Consultation Response from KC, Highways Development Management
2023/93759 12, George Street, Ravensthorpe, Dewsbury, WF13 3LL
Change of use from storage to garage, erection of single storey side extension and formation of vehicular access
Date Responded: 15/07/2025. Responding Officer: D. Stainsby Responding Ref: K14-4SW/1

A revised application was submitted in January 2024 for a change of use from storage to garage, erection of single storey side extension and formation of vehicular access at 12, George Street, Ravensthorpe, Dewsbury, WF13 3LL

DRAWING No
A1-CAD/01A

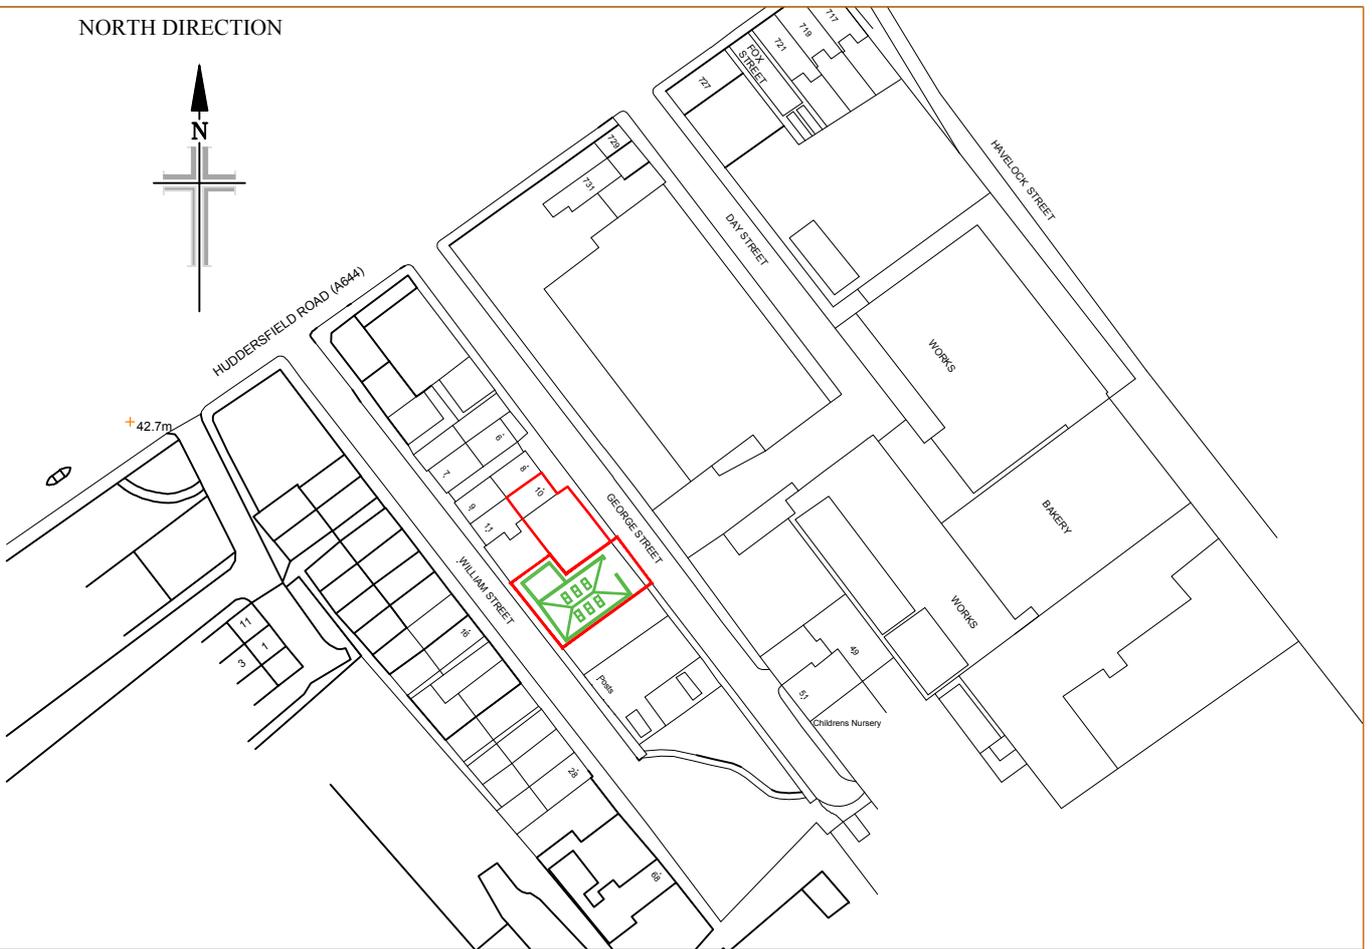
The new vehicle access proposed from George Street has been widened. But this does not still extend across the whole of the frontage to provide vehicle access to the proposed parking area on the site frontage on George Street.

The parking area on the site forecourt fronting onto George Street is still too small to accommodate any vehicles without them overhanging the public footway and causing an obstruction to pedestrians.

A revised plan showing the dropped kerb extending across the whole of the site frontage needs to be provided.

The depth of the forecourt will need to be extended to a minimum of 5.0m from the back of the adopted footway into the site for this area to be able to accommodate parking safely.

DRAWING STATUS FOR APPROVAL		DRAWING No A1-CAD/02D	
DRAWN	MAMJID	DATE	24/03/2025
SCALE	1:100 @ A1	REVISION	D

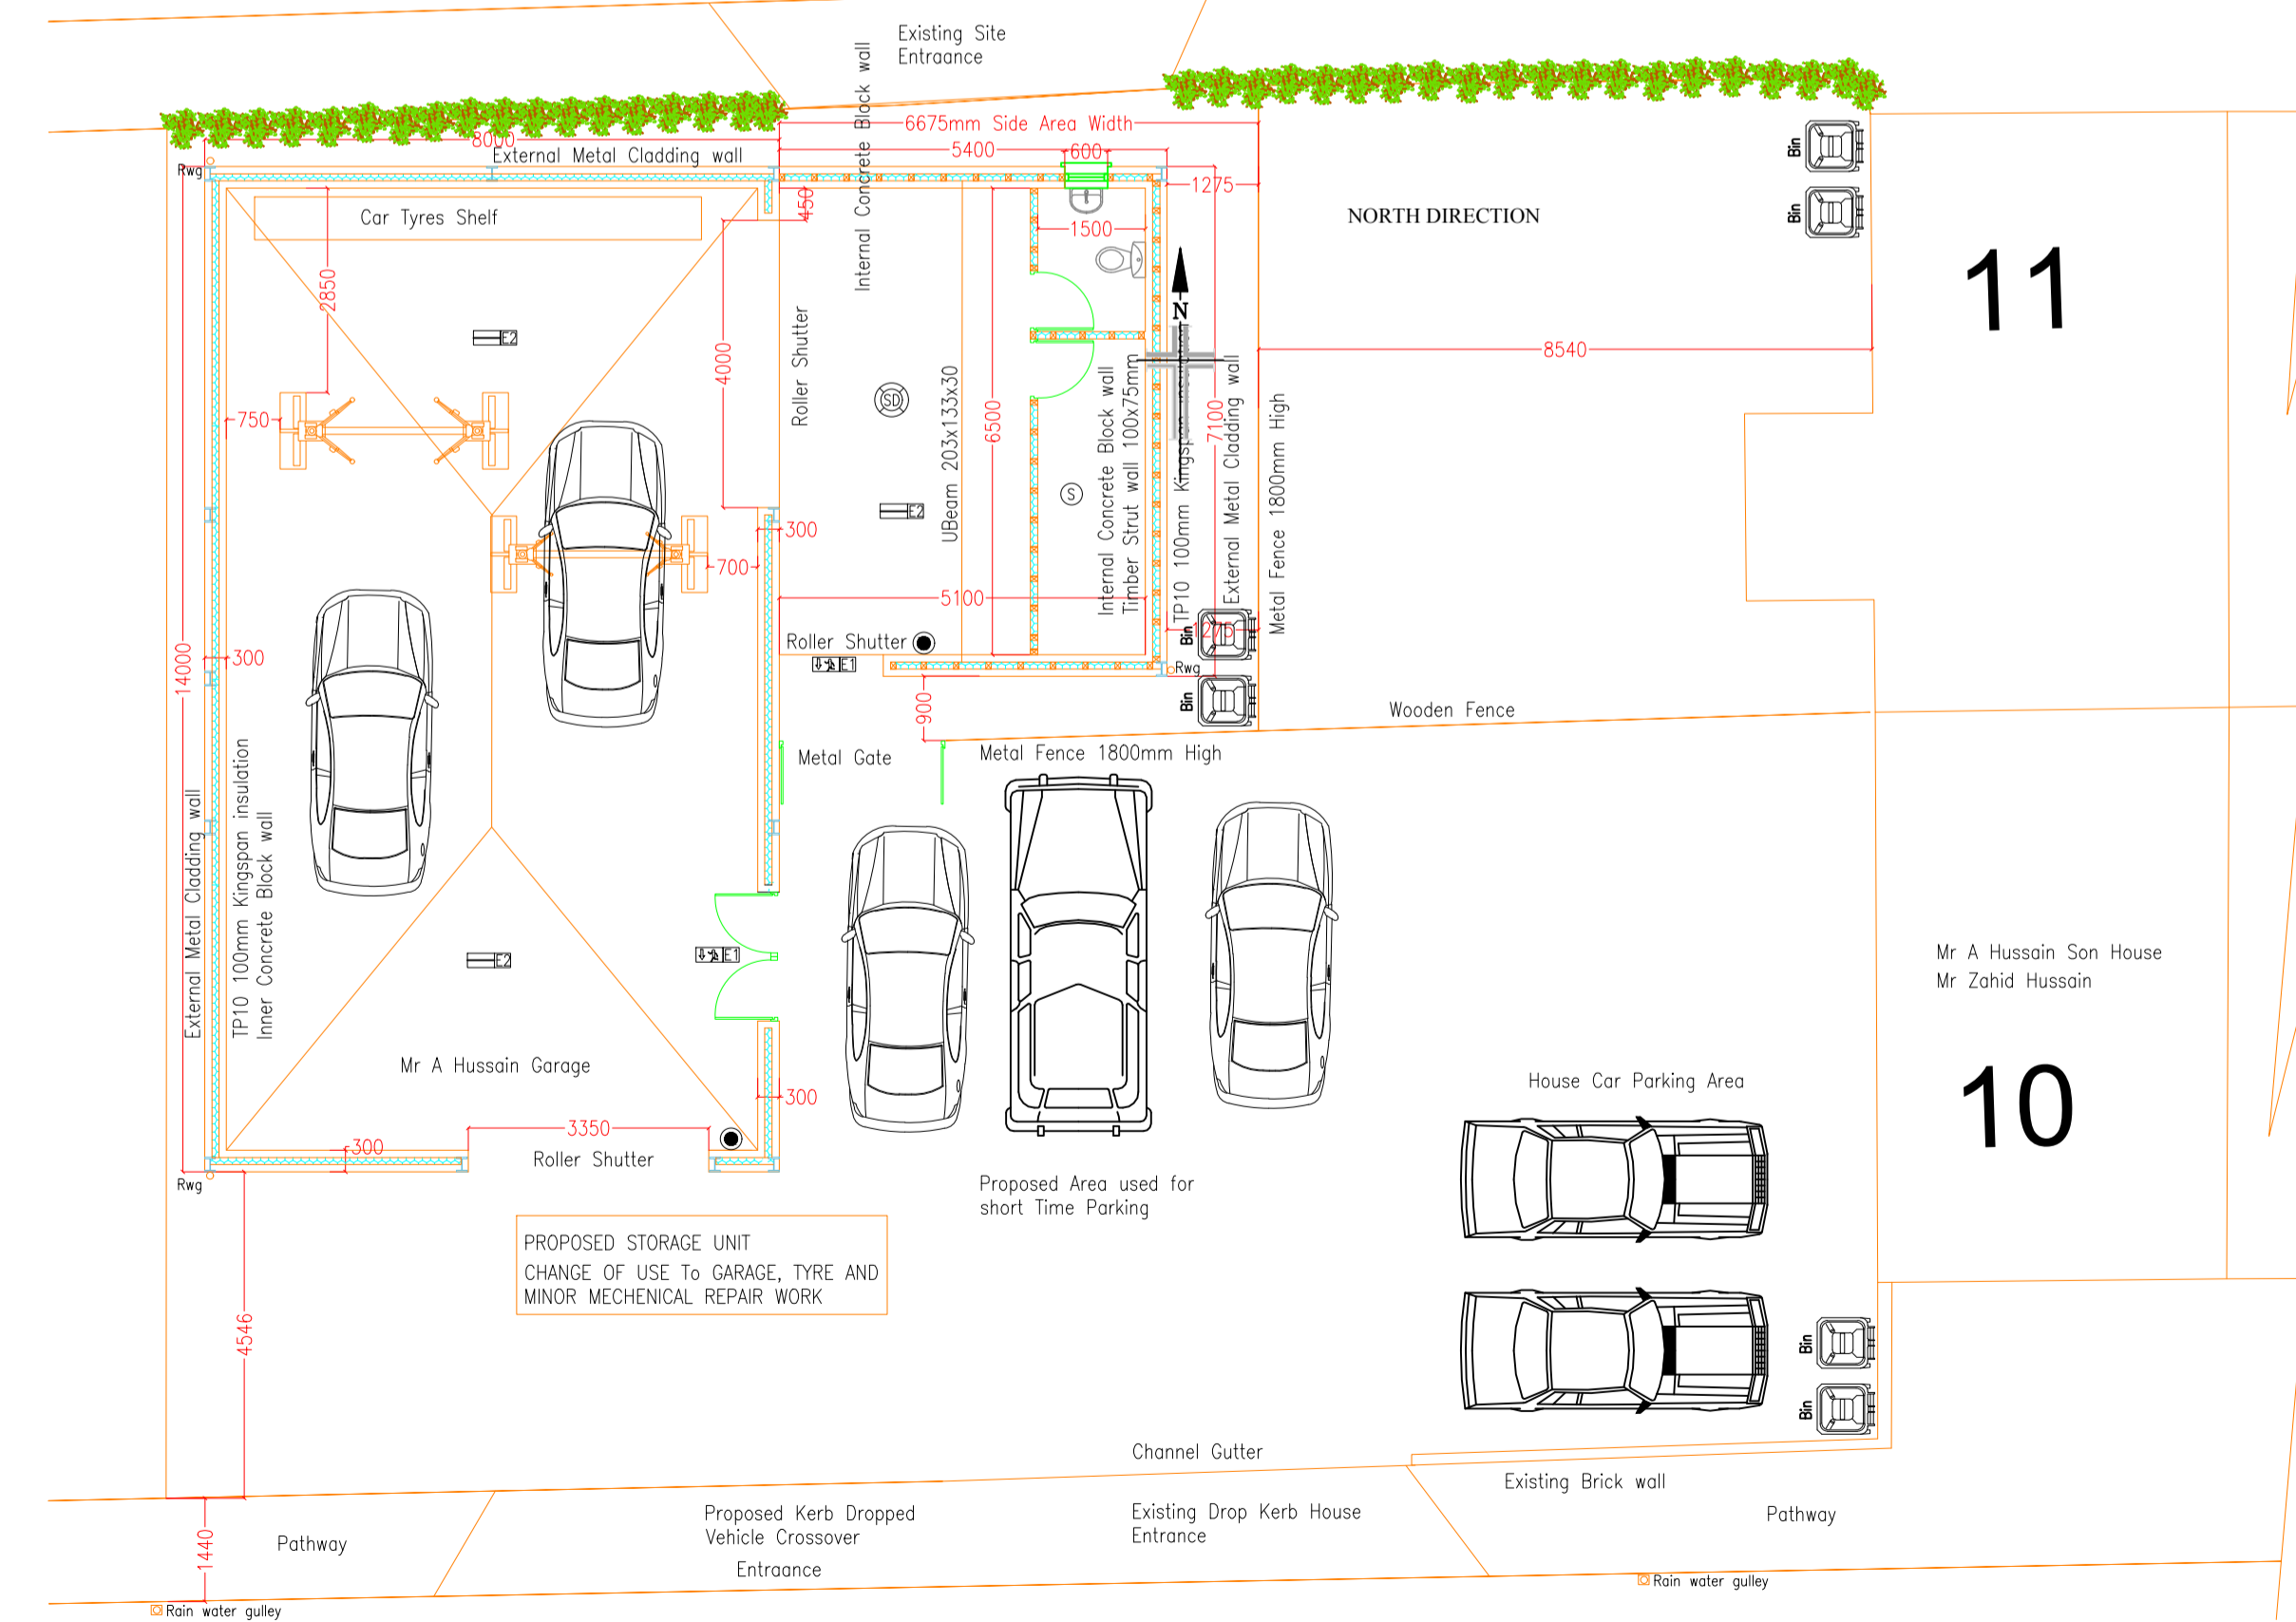
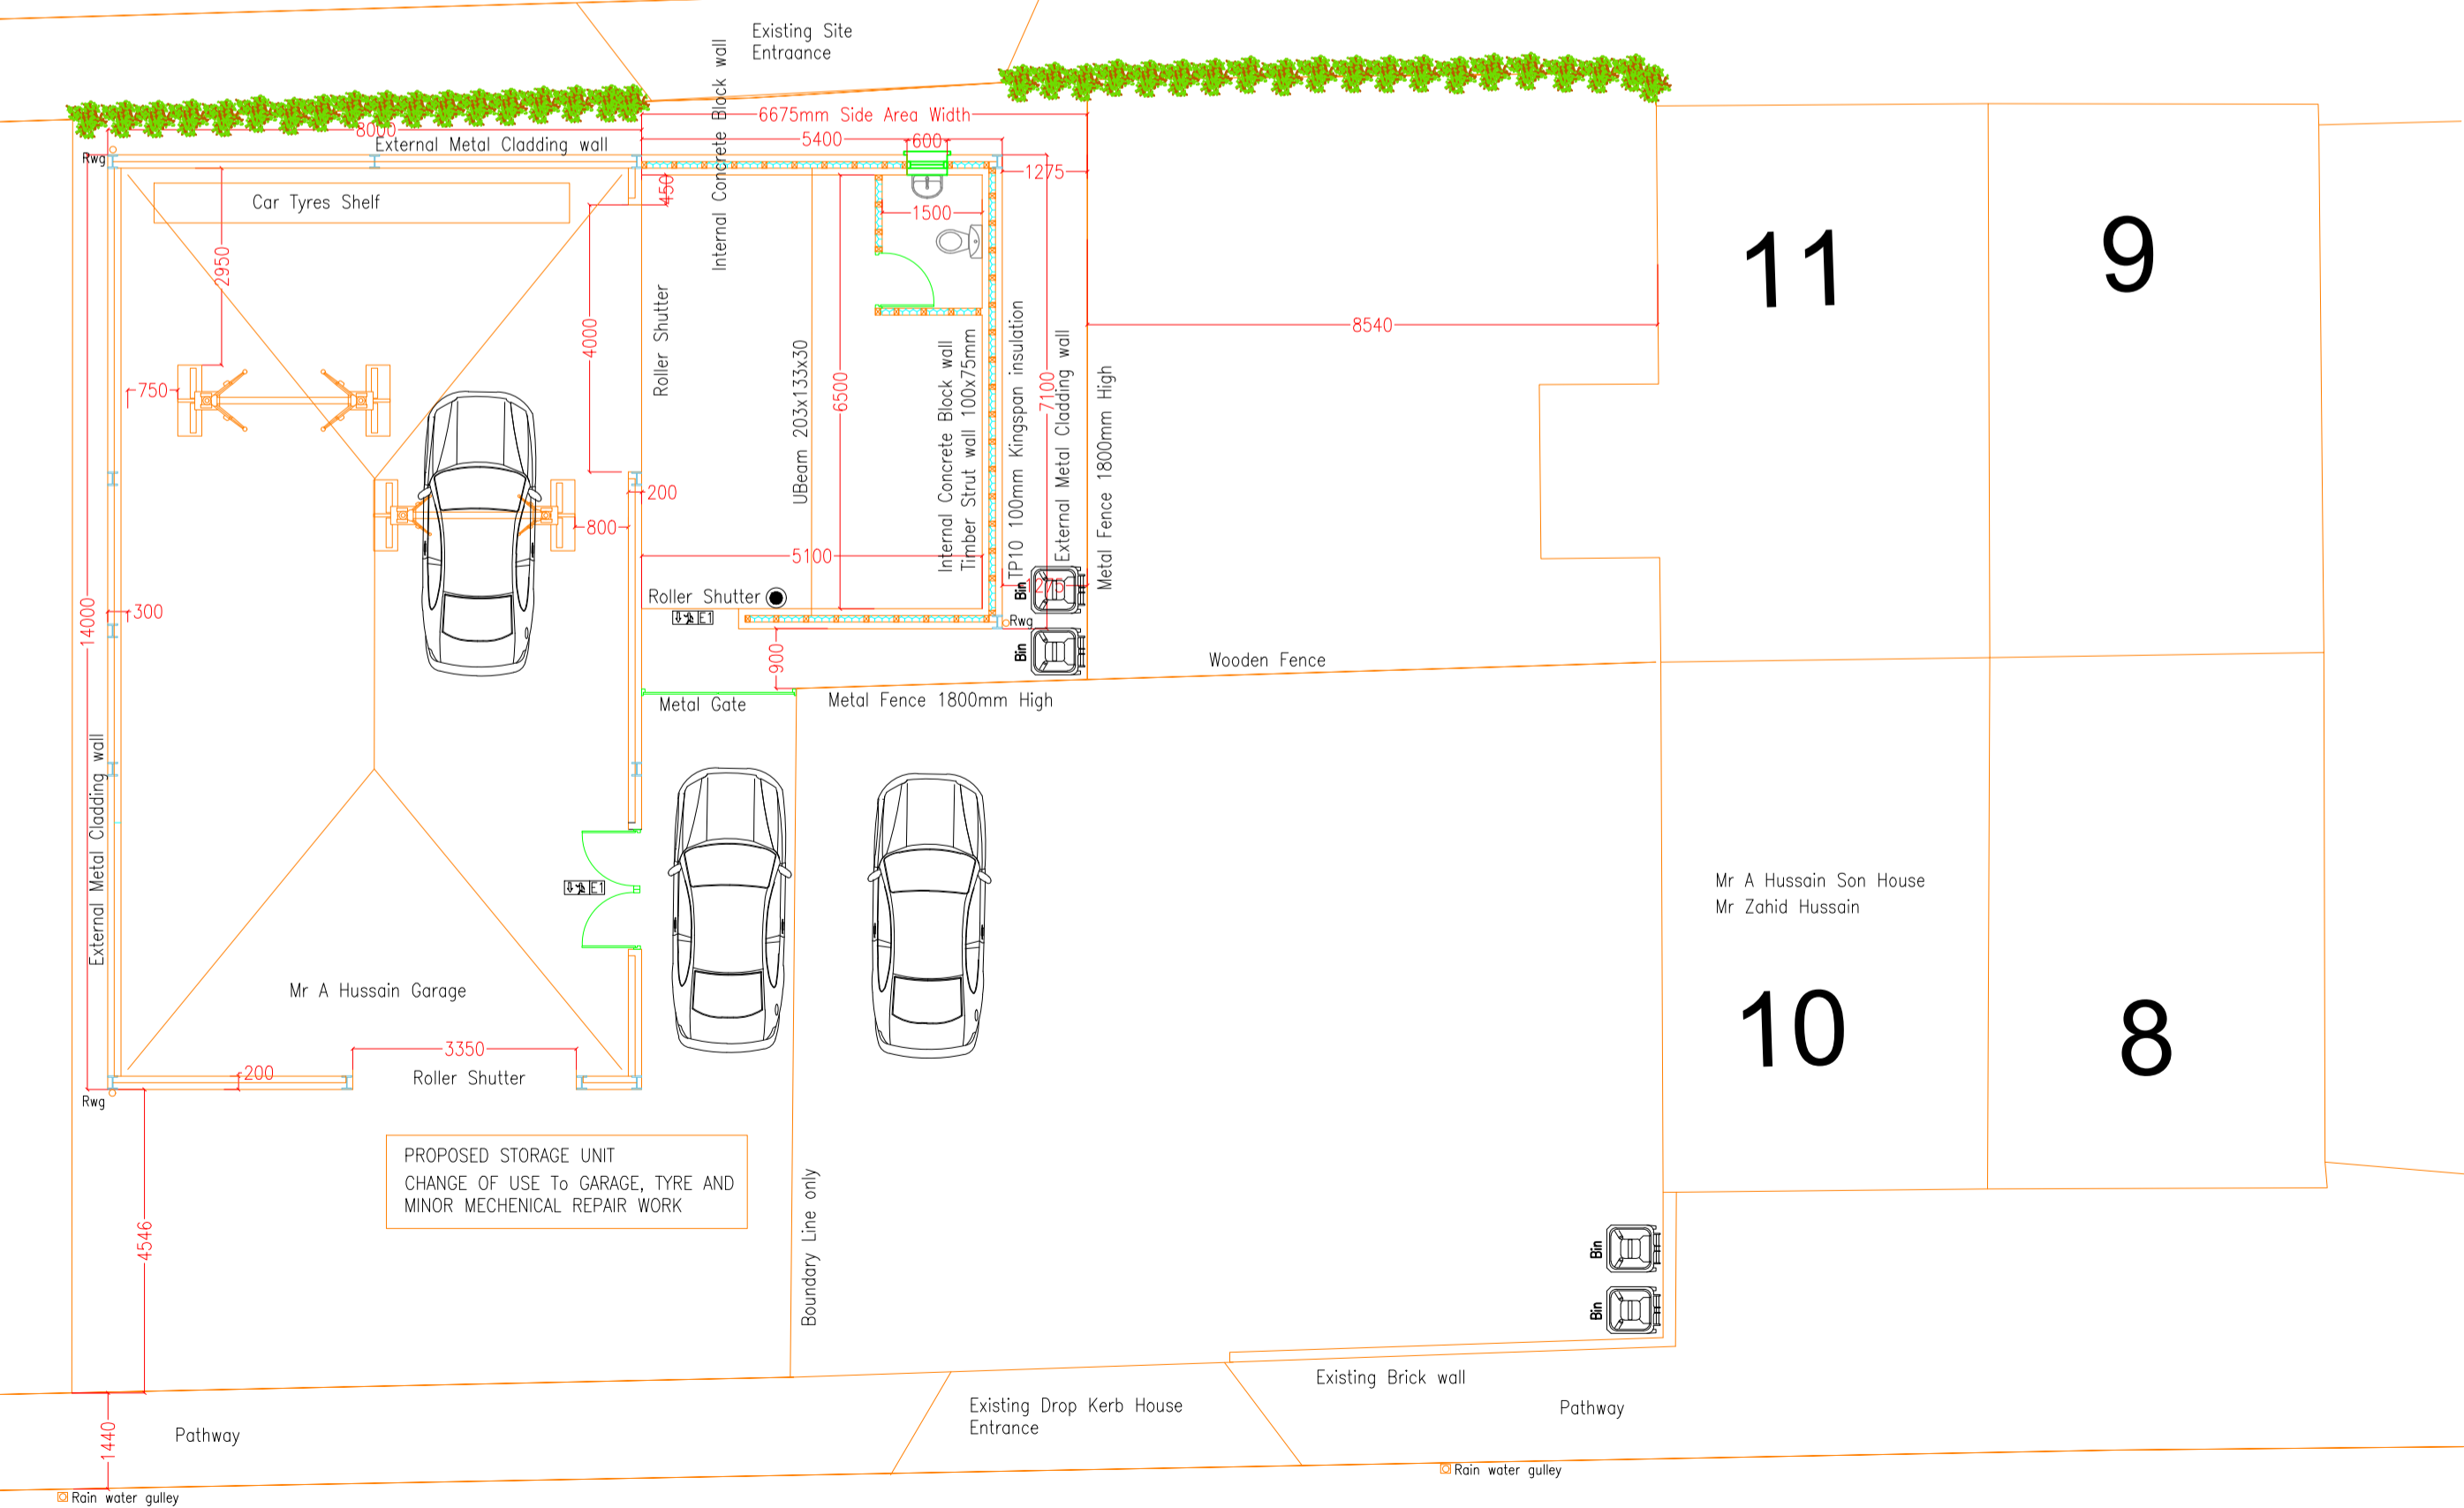
This further revised application appears to be the same and has not addressed my concerns.

The parking/yard area is proposed within the neighbouring land owned by No 11 George Street.

Currently No 11 George Street has off street parking which will be removed by this application. No alternative provision is proposed to replace the loss of this off-street parking. This parking will need to be provided elsewhere on the application site.

The proposal shows that there is potential for approximately 5 vehicles within the parking/yard area which is acceptable for the proposal. However, the applicant will also need to show the replacement parking for No 11 George Street and the waste/storage area for the proposed garage which will ultimately reduce the available parking for the proposal.

The proposed plan still shows only two typical residential waste bins on the site.

Bearing in mind that the proposed use is for a garage and tyre repair centre the waste/storage area will need to be increased substantially, and the proposed size and location demonstrated on a plan.

A separate bin storage area will need to be provided for No 11 George Street

- A revised plan showing the replacement parking for No 11 George Street needs to be provided.
- A revised plan showing a suitable waste/storage area on the site together with a bin storage area for No 11 George Street needs to be provided.
- A revised plan showing the dropped kerb extending across the whole of the site frontage needs to be provided.
